September 28, 2023

Re: PA23-005 – Creekside PRD – Technical Review 2
7808 40th Street, 7811 & 7715 40th Street NE, APNs 29050200100200,
29050200100300, and 29050200100400

The following comments are required to be addressed prior to a SEPA determination being issued:

**RD-01**  
SHEET 6 OF 15

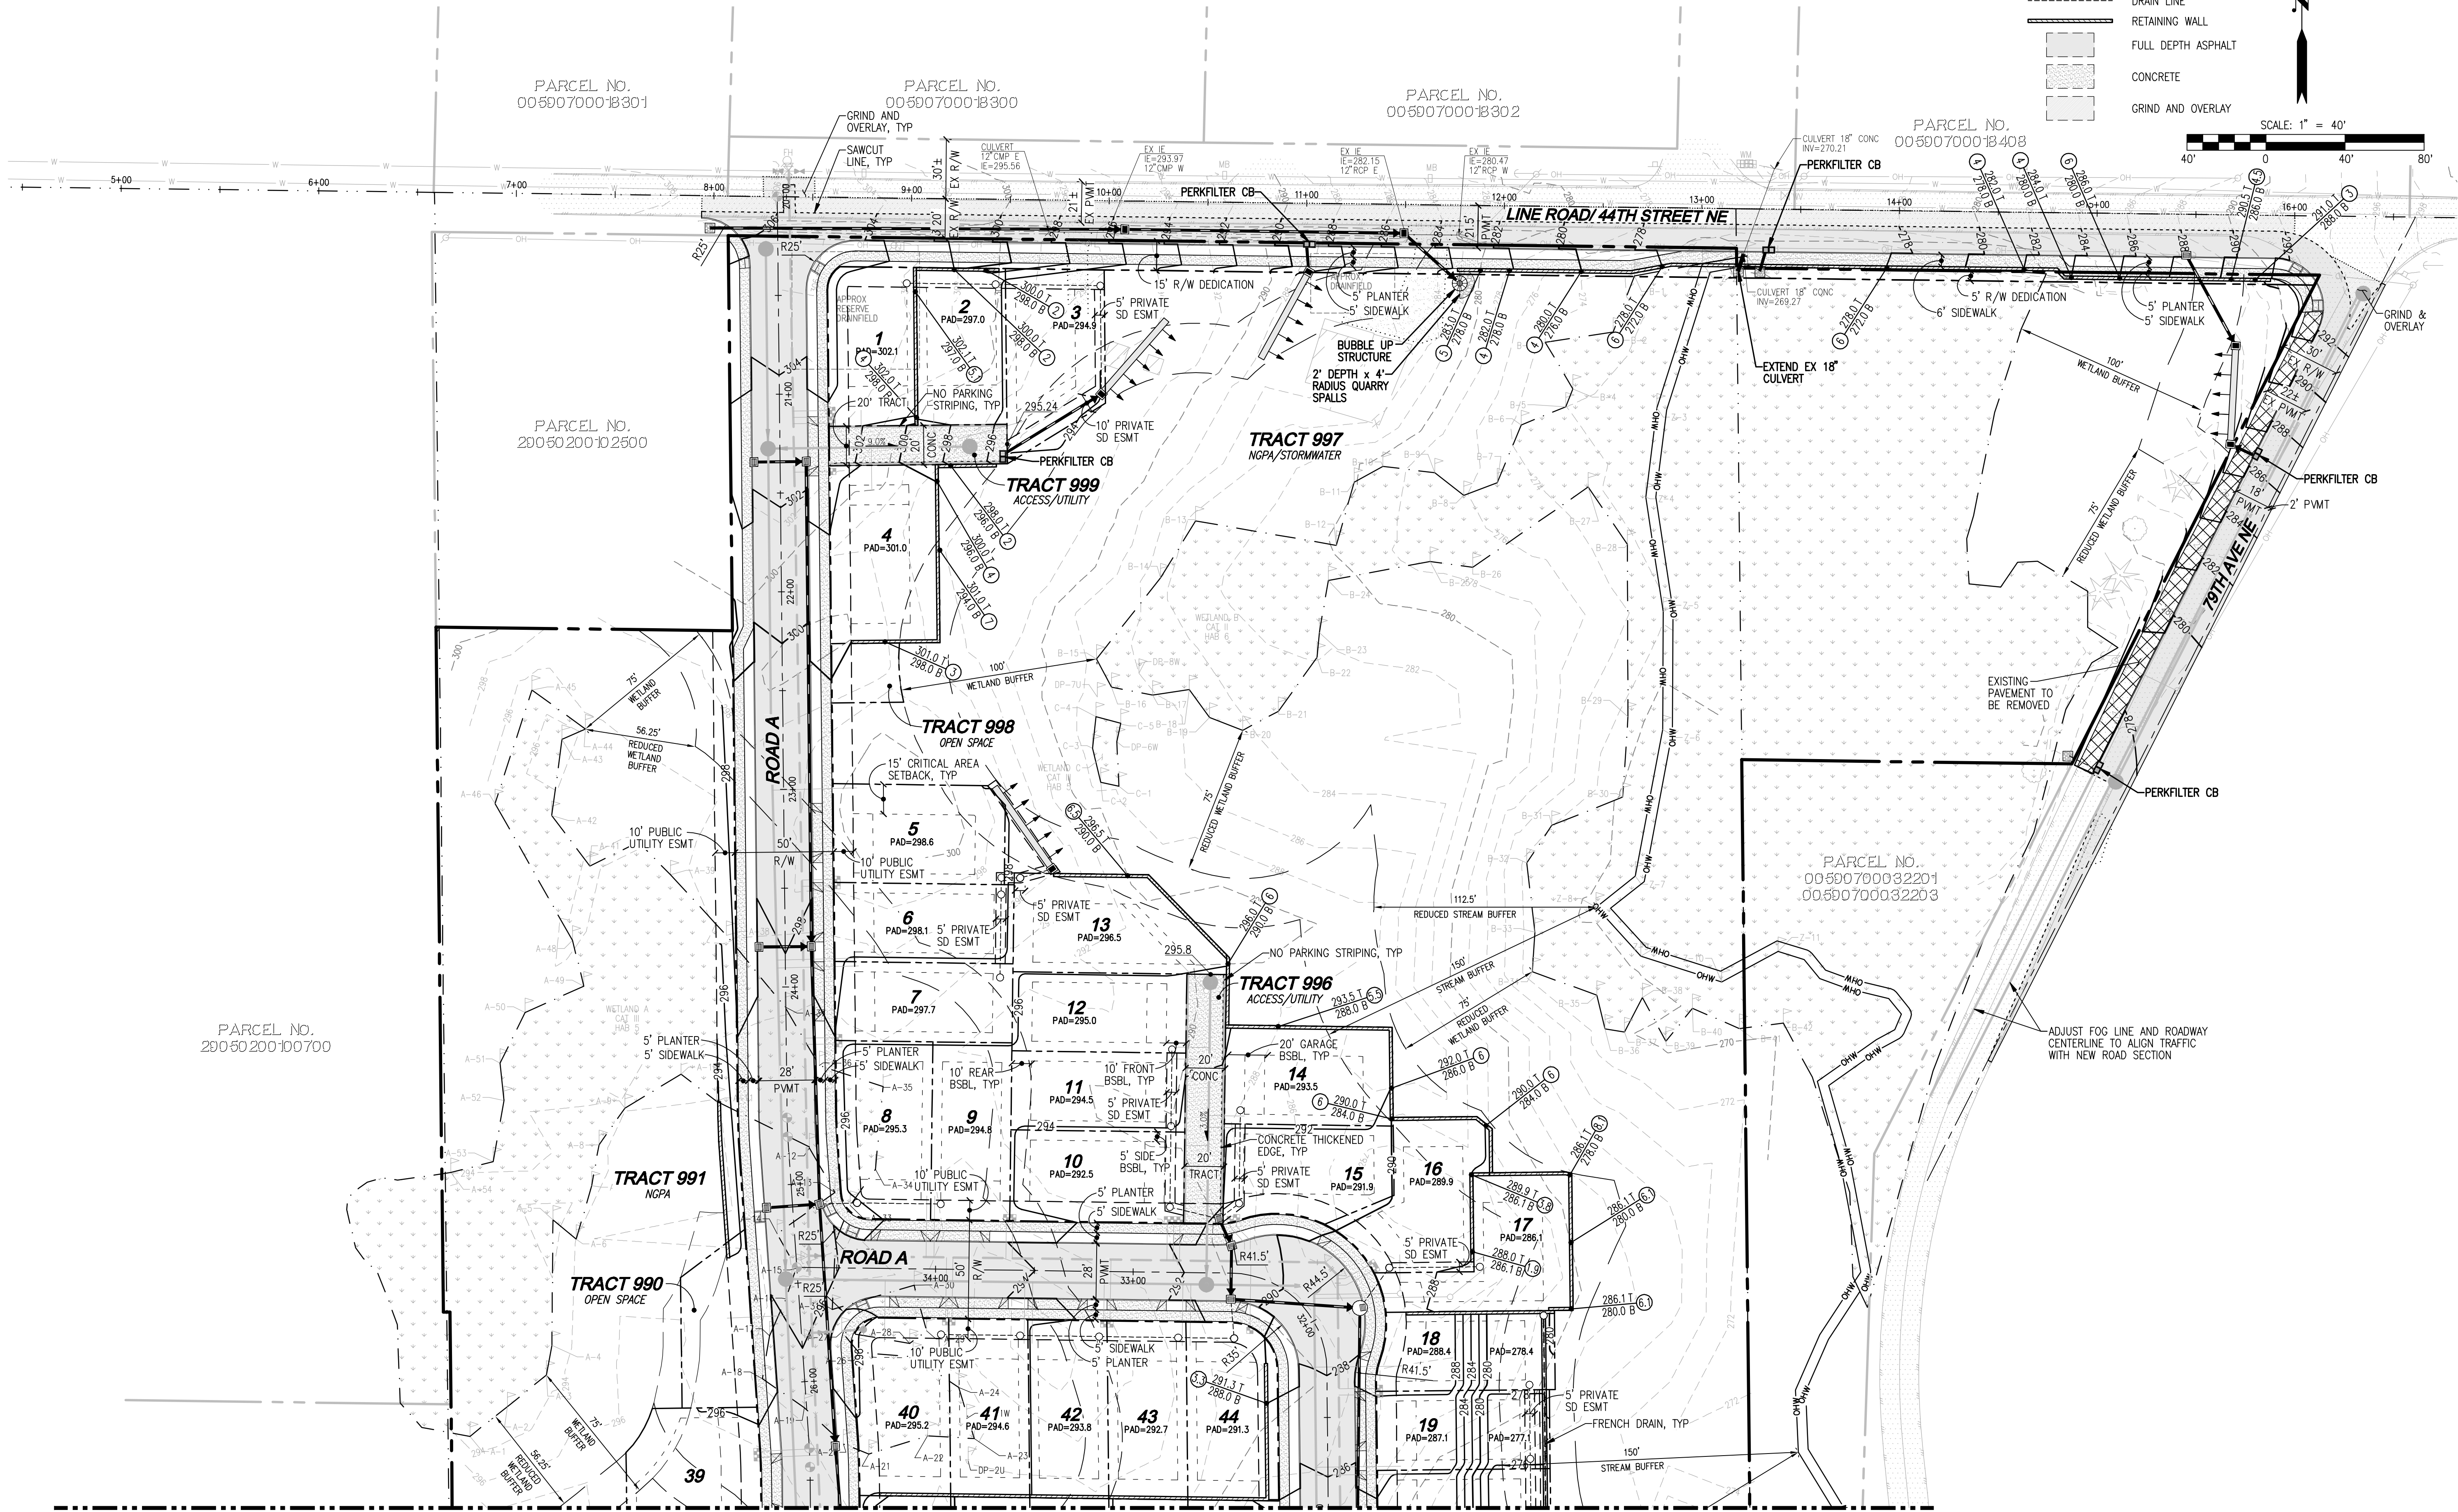
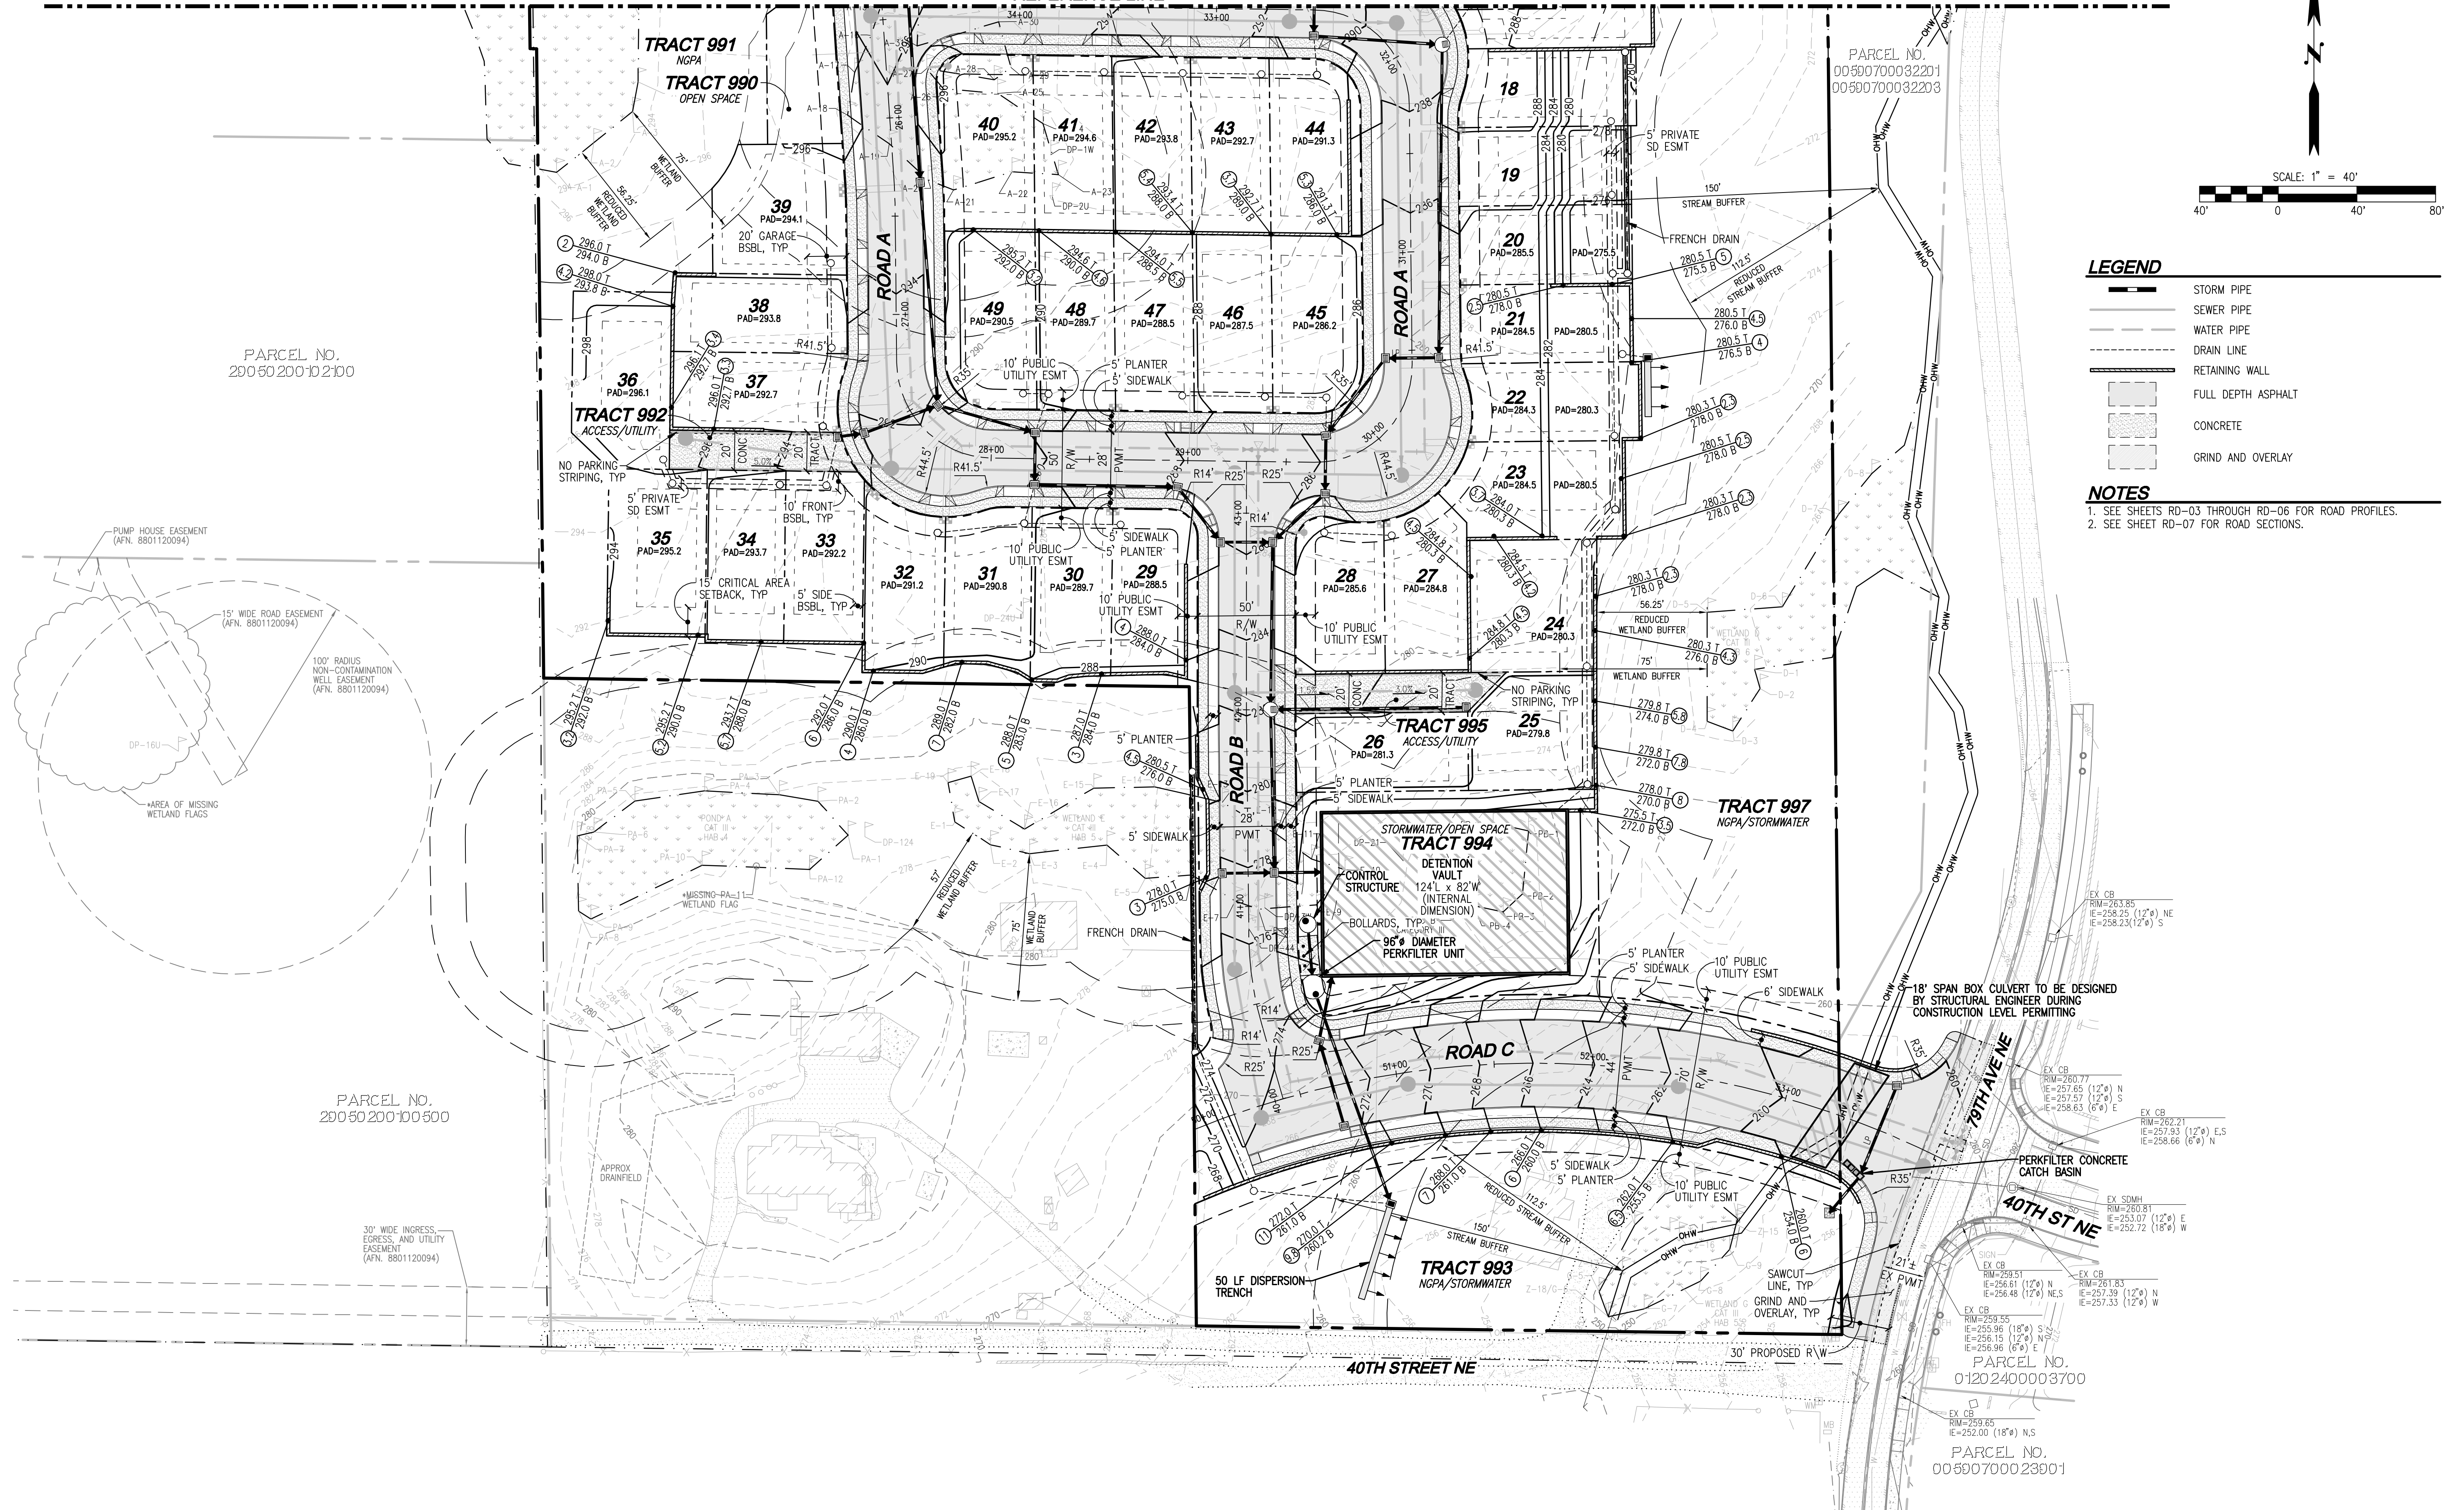
6. Pursuant to MMC 22D.050.030(4)(e), retaining walls taller than four feet shall be terraced so that no individual segment is taller than four feet. Walls between lots 44 and 49, 27 and 24, along the southern boundary of lots 29-35, adjacent to 44th Street, and in scattered other locations, exceeding four feet will be required to meet the terracing requirements below. Lots directly abutting the wetland *and not visible* from adjacent lots or roadways are not required to meet these standards. Compliance will be verified during civil construction plan review.

HORIZON VIEW HOLDINGS, INC.
CREEKSIDE
PRELIMINARY PLAT

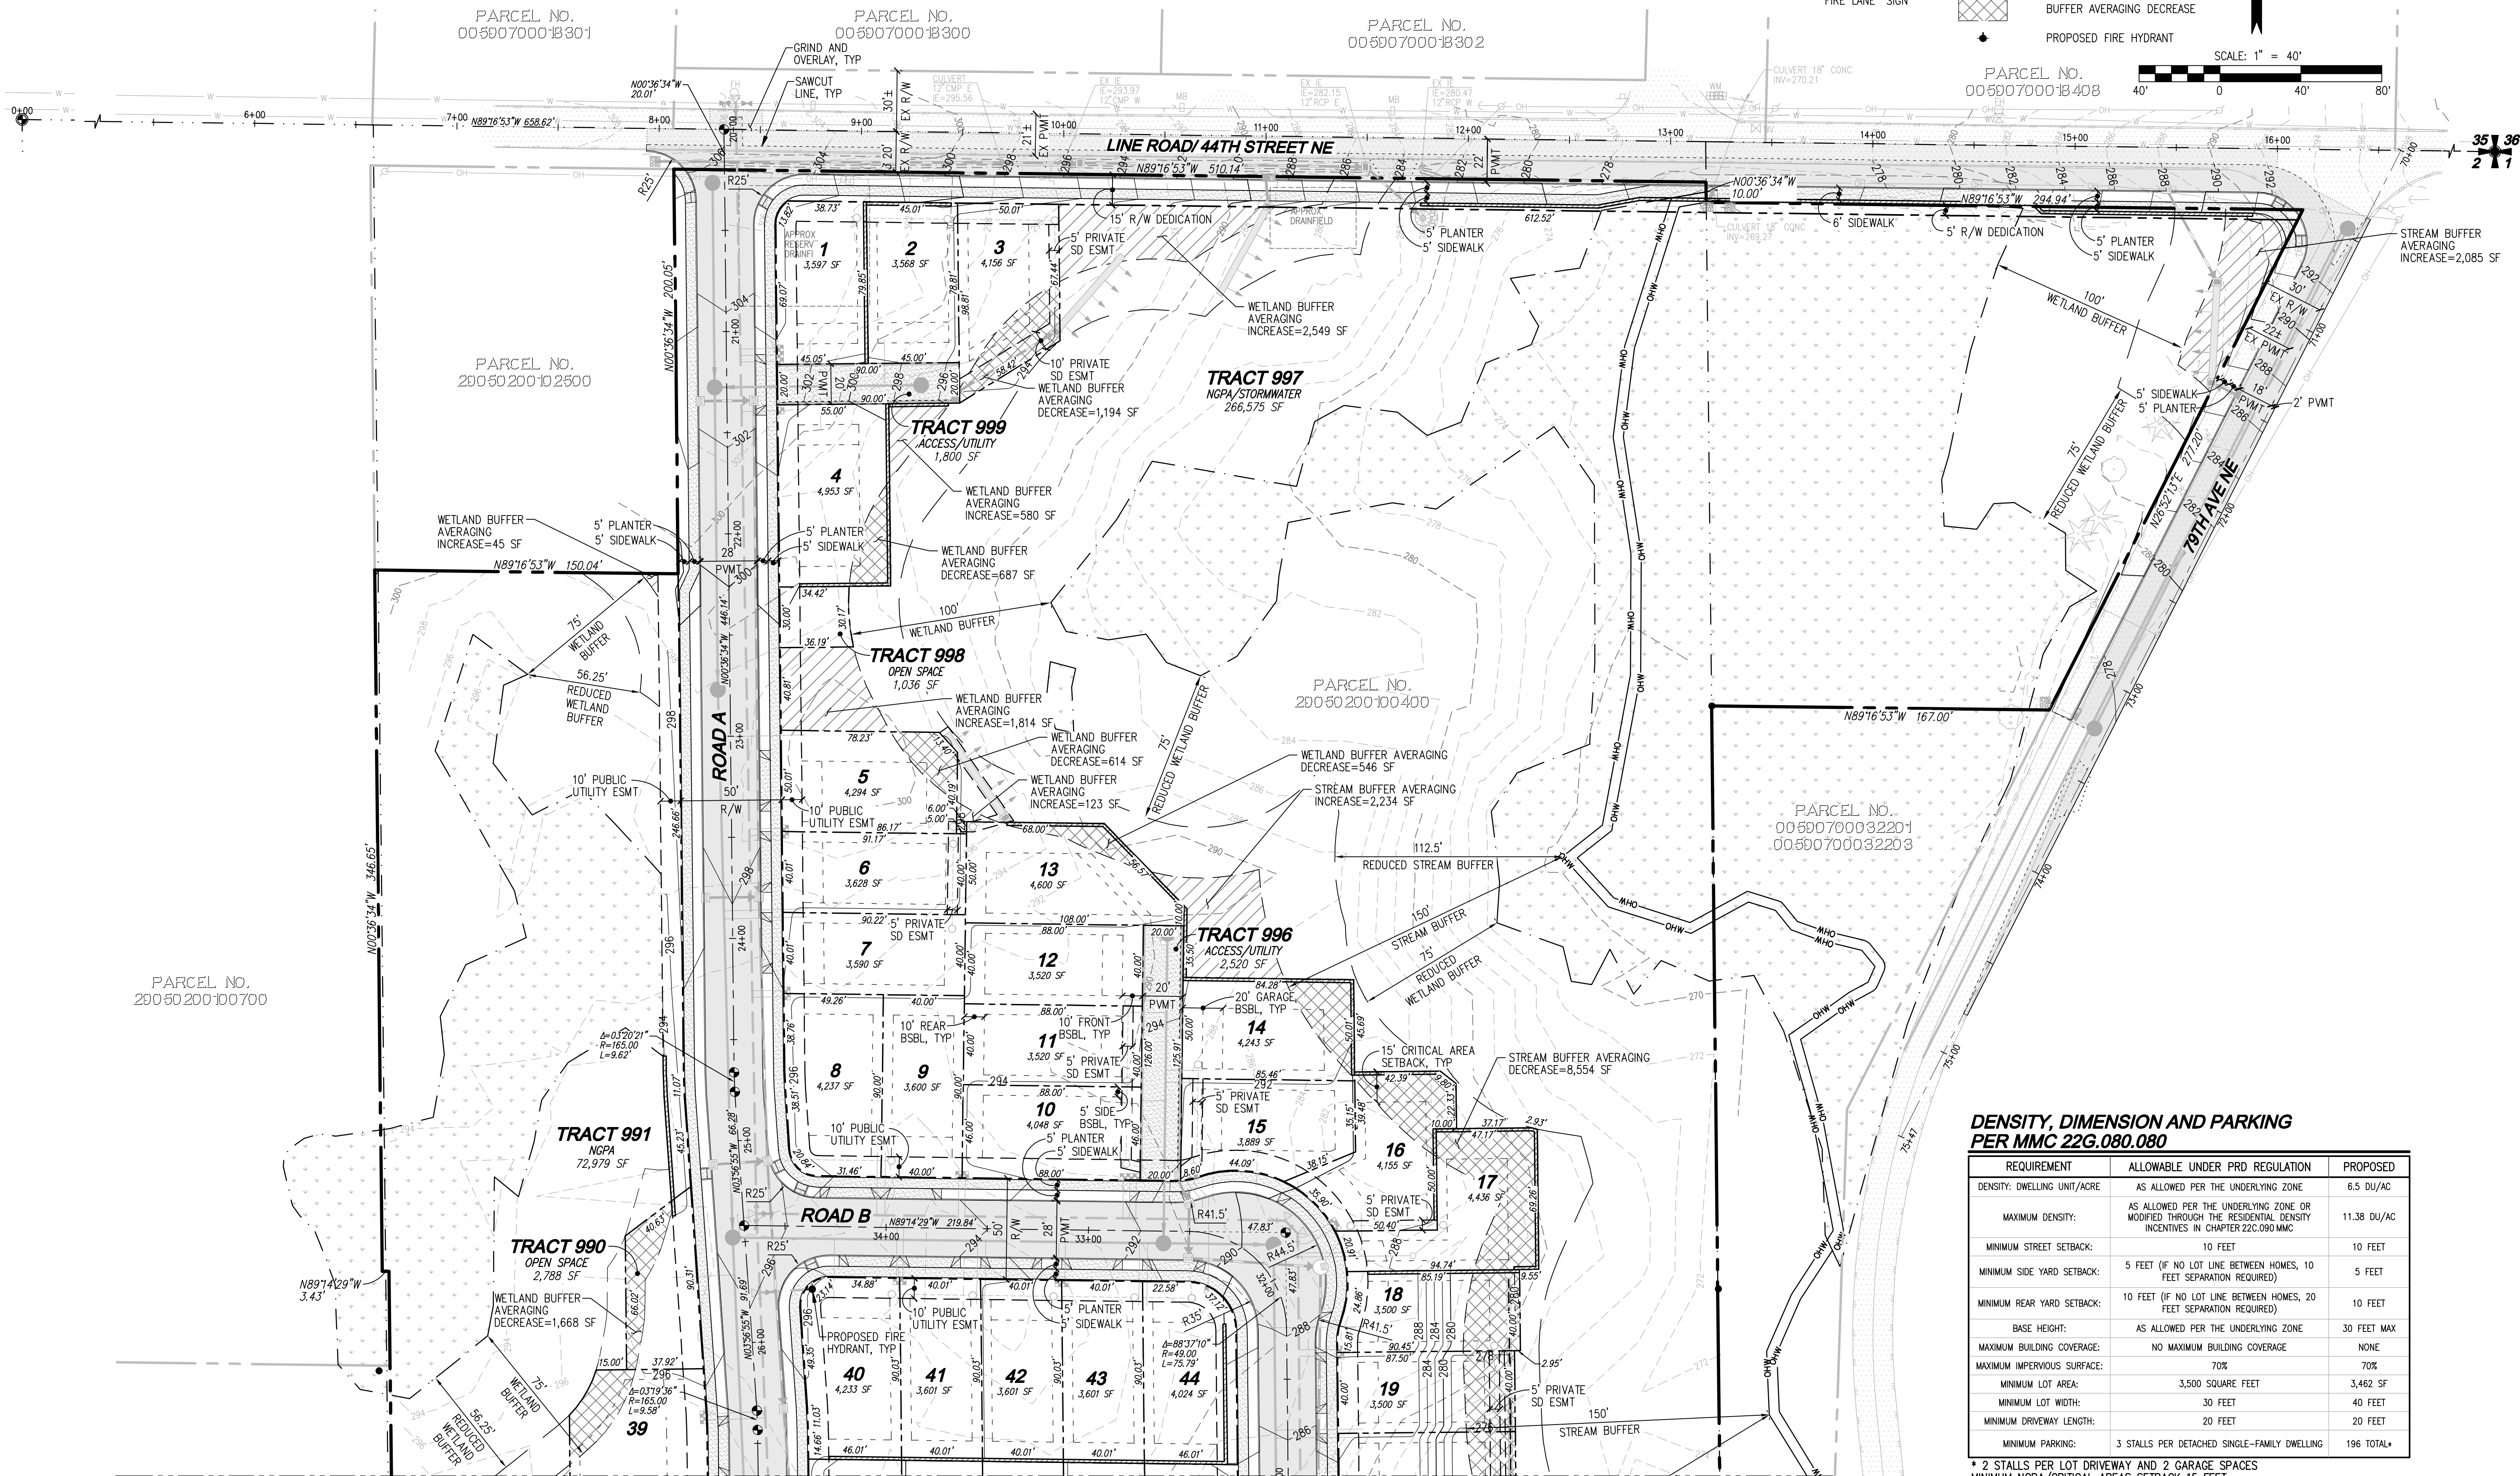
4. Bulk and dimensional standards for a PRD are outlined in [MMC 22G.080.080](#). The table on sheet 2 of the Preliminary Site plan indicates a lot size that does not meet the minimum; see below.
